From: Russell McCourty [REDACTED]
Sent: 22 September 2017 11:13
To: Anita Gardner
Subject: RE: WA/57/17/PL Balcony screening - 1 and 2 Stafford Cottages

From: Anita Gardner [REDACTED]
Sent: 20 September 2017 13:09
To: Russell McCourty [REDACTED]
Subject: WA/57/17/PL Balcony screening - 1 and 2 Stafford Cottages

PROPOSED ELEVATIONS 1:100

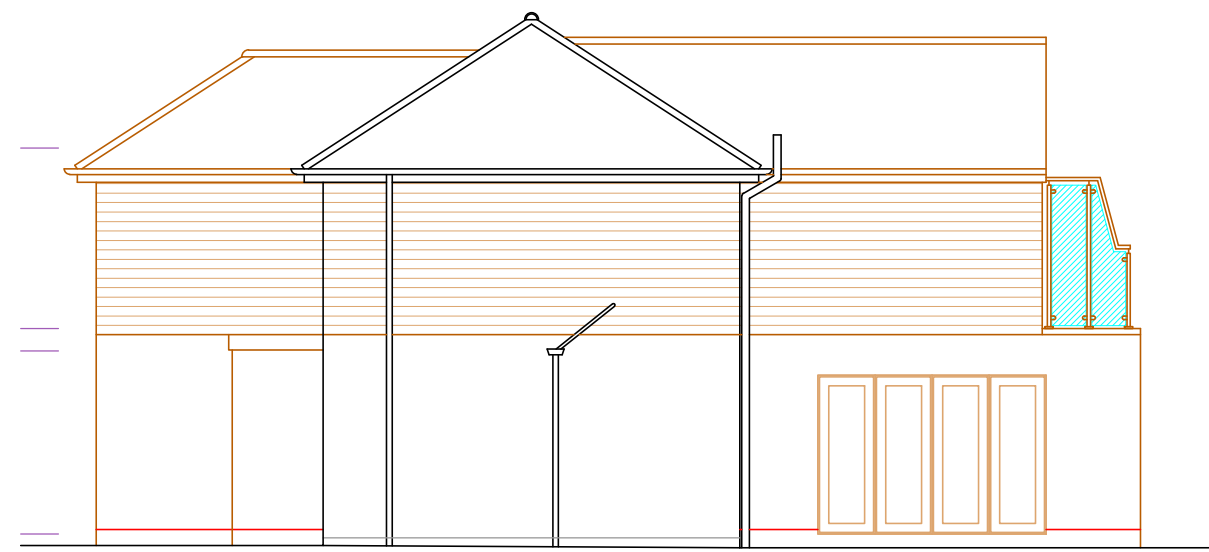
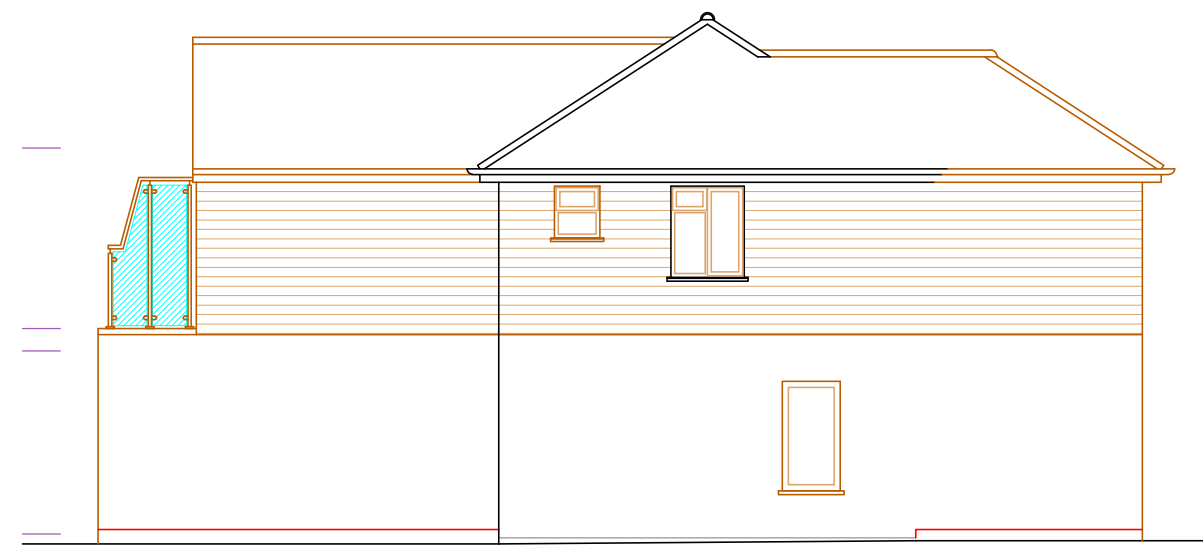
Dear Russell,
I have started to look through the above application with a view to getting it onto the October committee agenda . I note that the 1:20 balustrade elevations do not coincide with submitted photographs. There is a gap around the

glazing which is not detailed on the submitted elevations. This will need to be amended prior to Committee on 18-10-2017.

By my investigation, I can say that the gap between the vertical metal post and the glass is approximately 22mm.
Amended drawings attached.
